STATUTORY PLANNING CONSULTATION RESPONSE

Application Number:	3/2026/0315
Proposal:	Residential development of 39 dwellings with associated landscaping, car parking and access.
Location:	Land off Chatburn Road Clitheroe BB7 4JX

The Lead Local Flood Authority **objects** to the above application on the basis of:

Objection 01 – Inadequate Surface Water Sustainable Drainage Strategy

Section 1-1 1:250 Scale

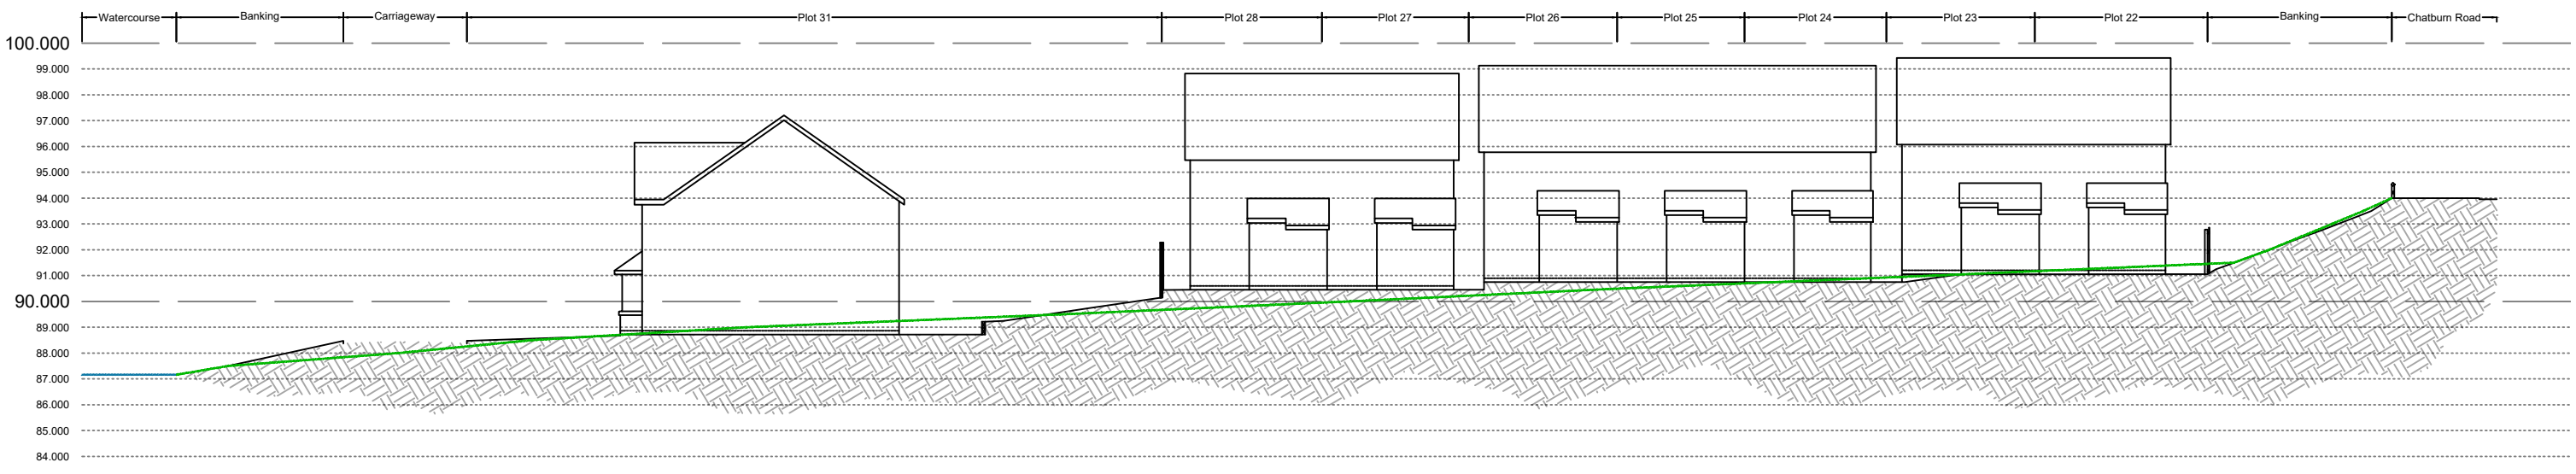
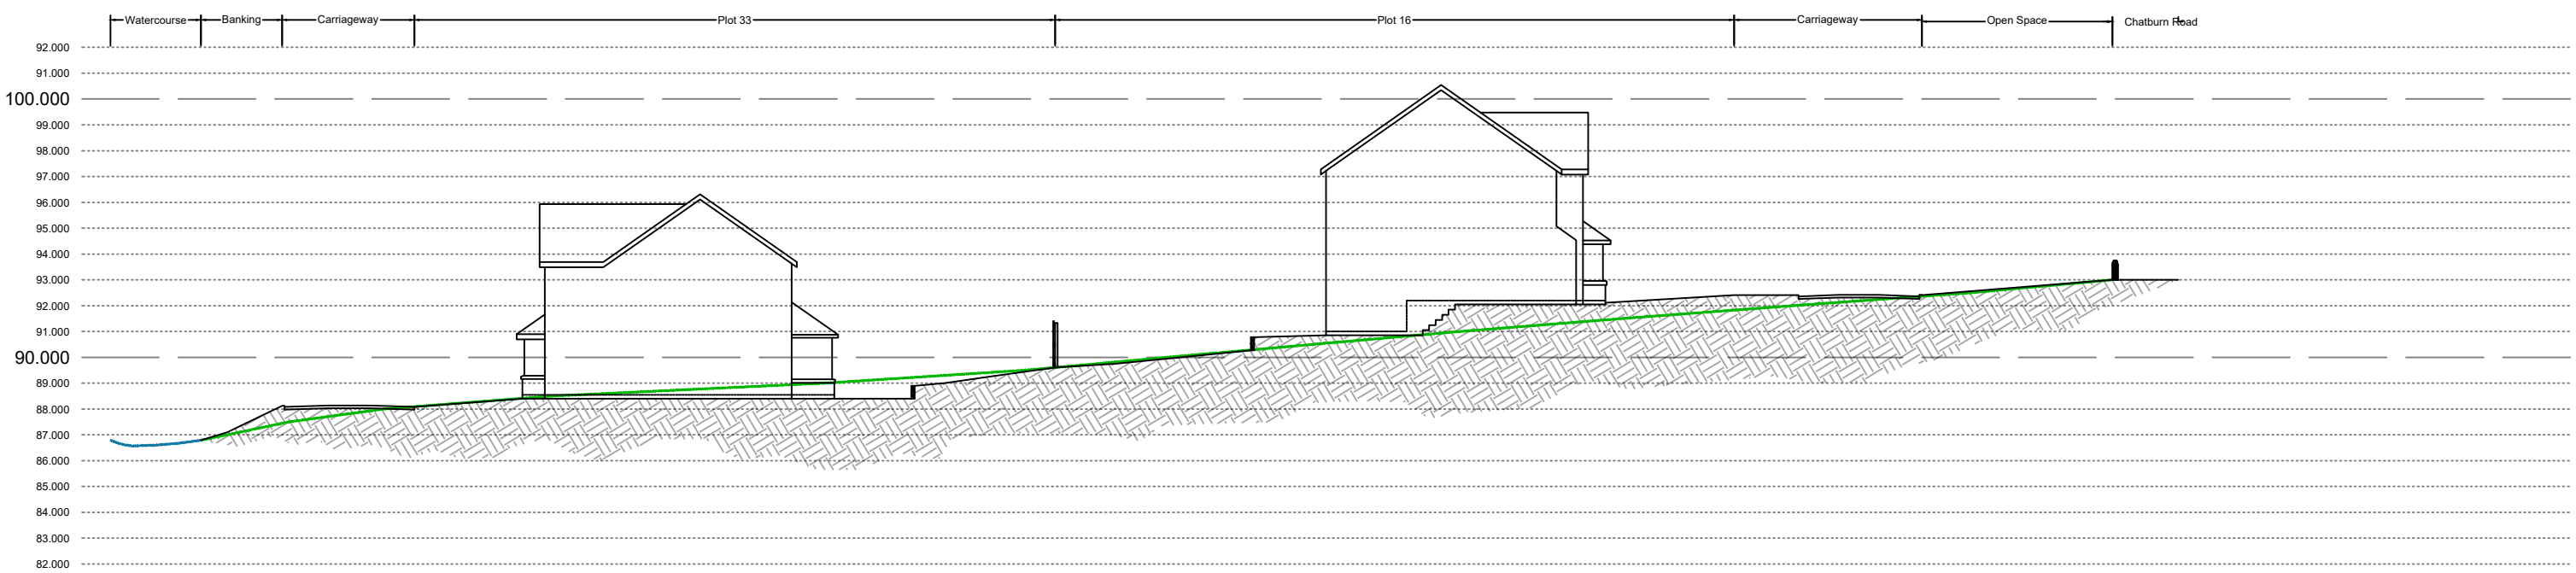
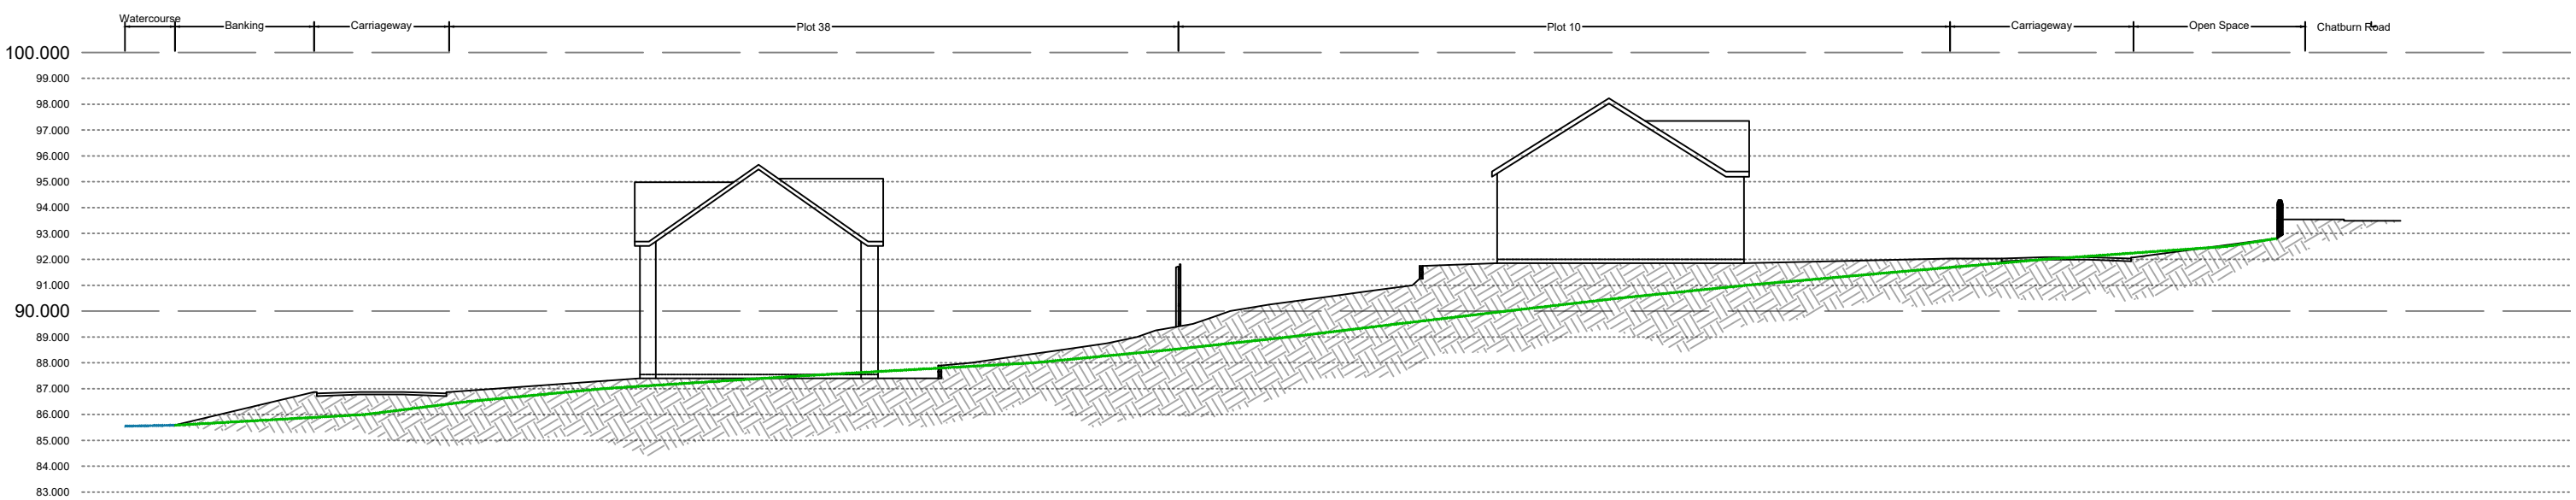
Specifically, the applicants drainage layout shows that some houses(especially the central houses) which gardens back on to each other as being a potential flood risk due to the fact that the houses to the north have a lower finished floor level than those houses to the south and the gardens showing an approximate fall of 3 metres and an approximate 1in5 slope from the southern houses to the northern houses, with no mitigation proposals, especially given that the applicant has stated that infiltration is unfeasible and that ground water was present at approximately 1m to 1.5m below ground that . This is sufficient reason in itself for the refusal of planning permission.

DRAINAGE LAYOUT
SHEET 2

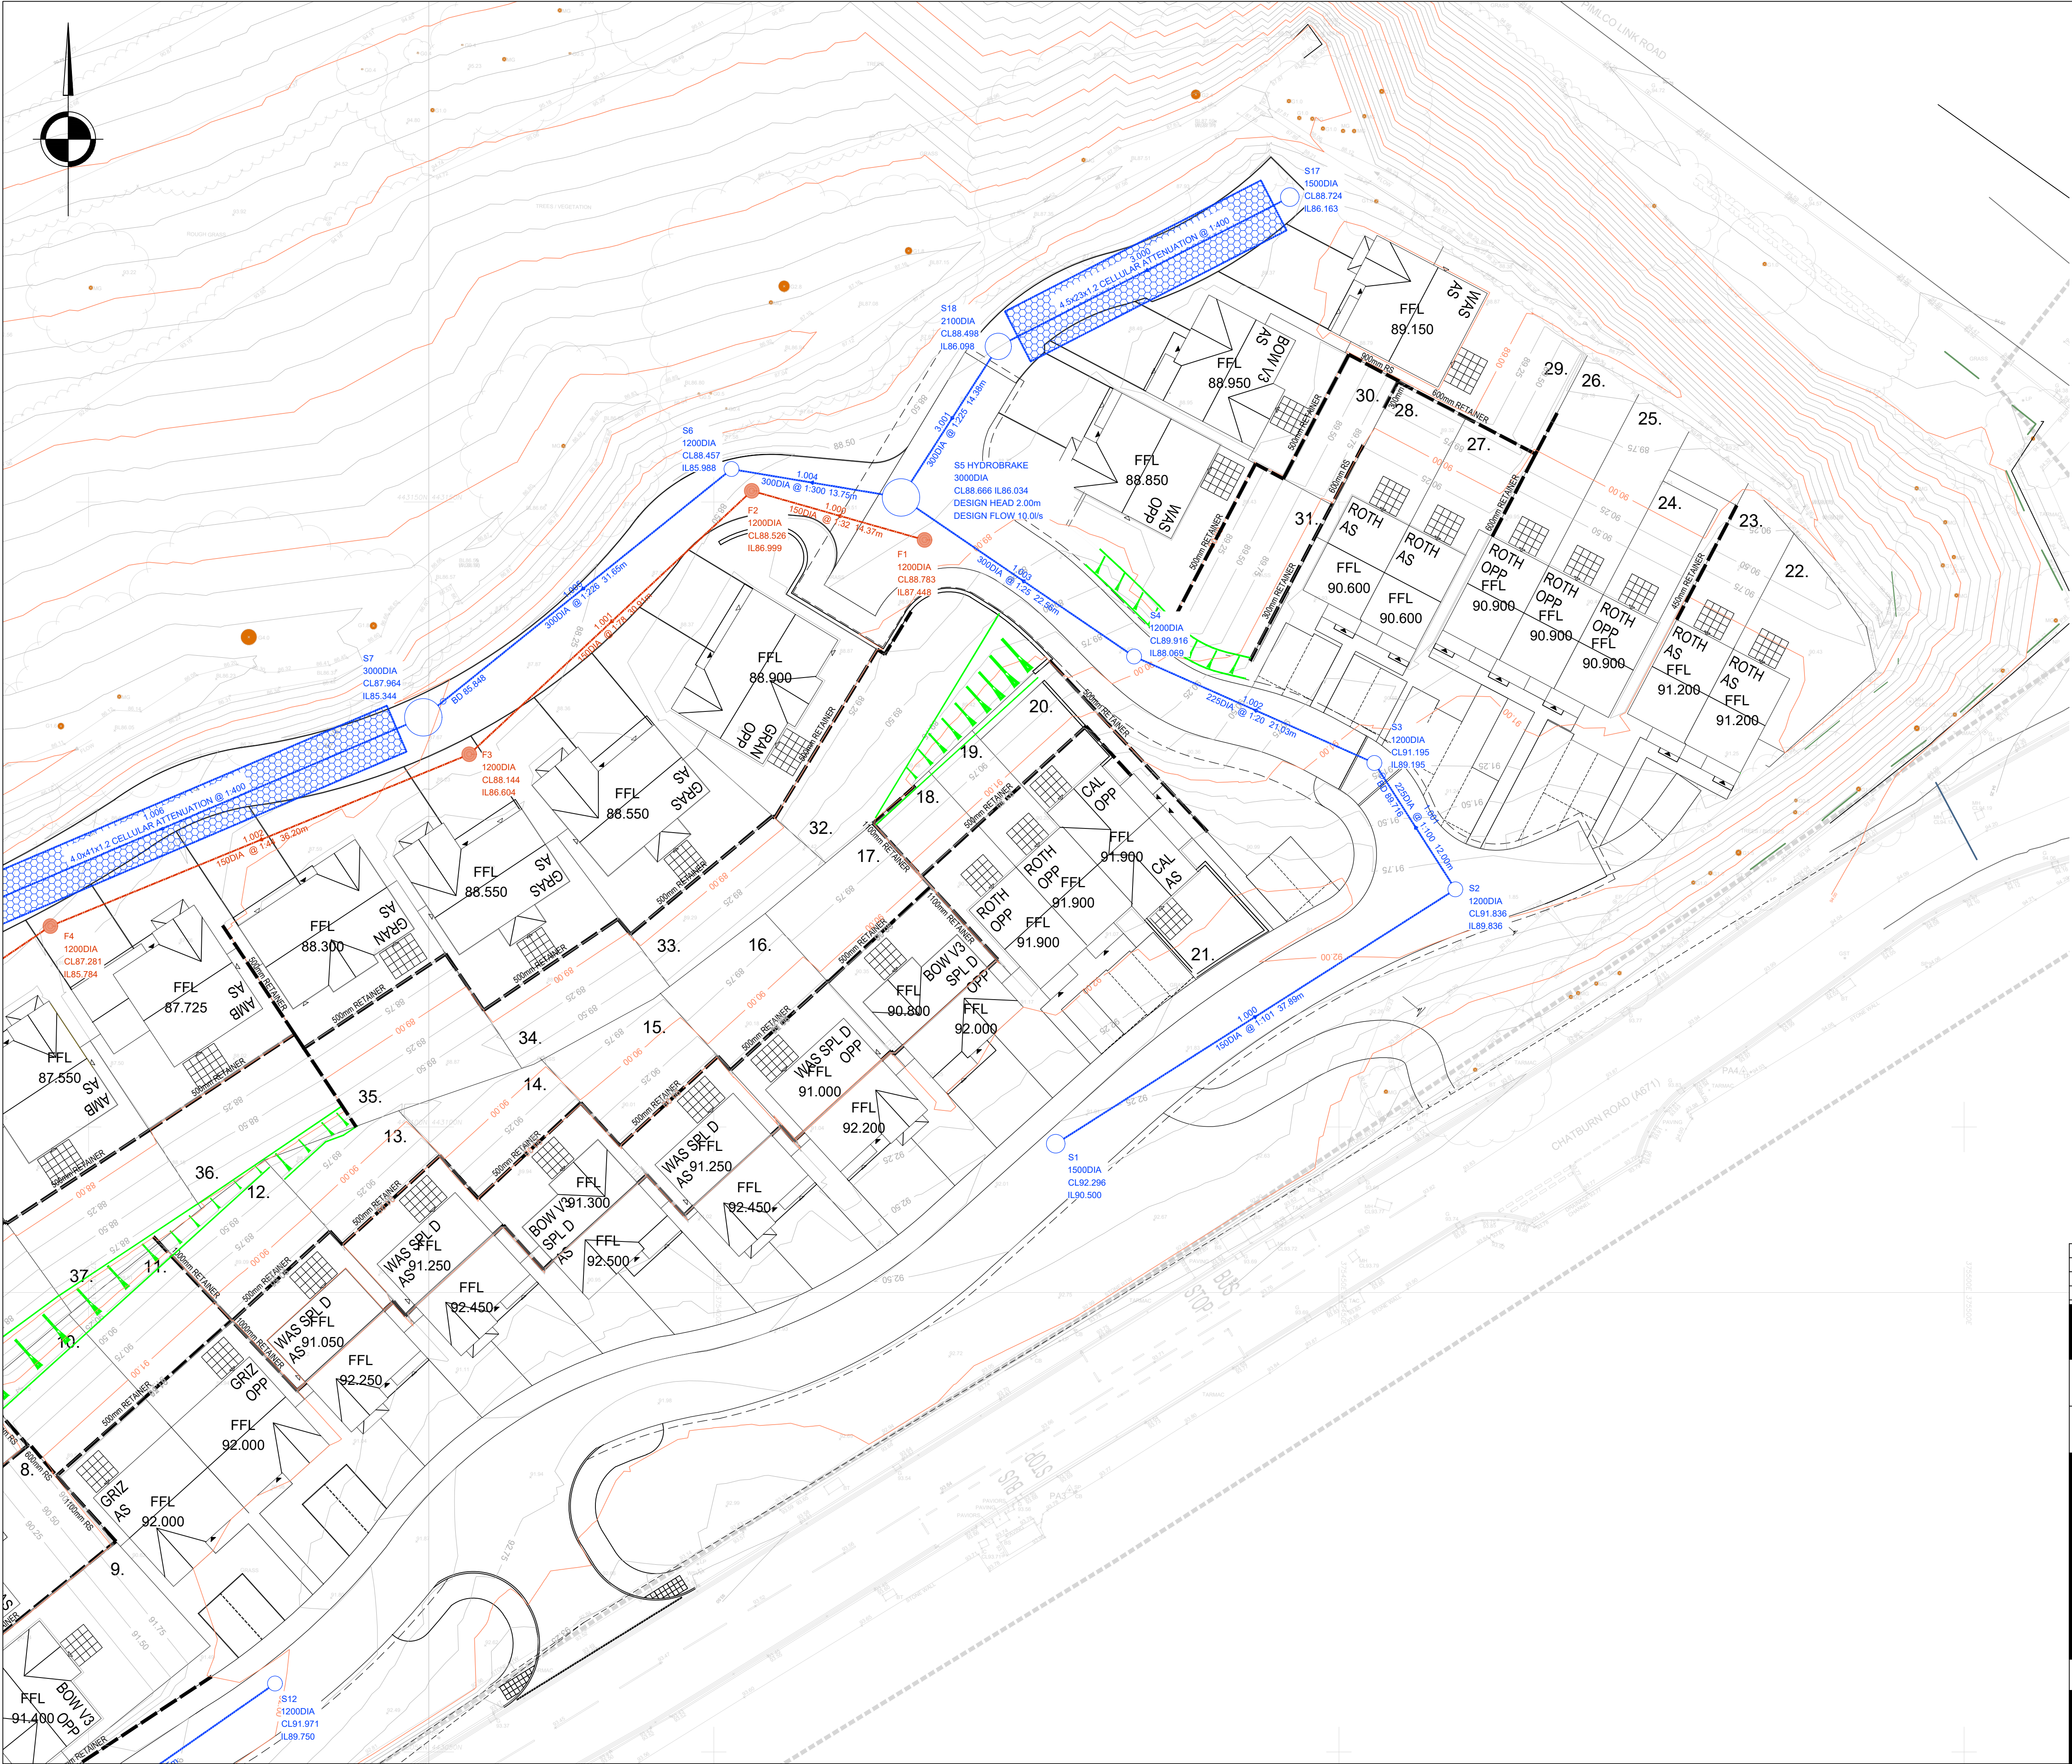
- It is unclear from the submitted evidence how the applicant intends to drain the houses and road between manholes S12 and S1, from the initial information provided this appears to be a significant area to drain via the use of private drainage only.
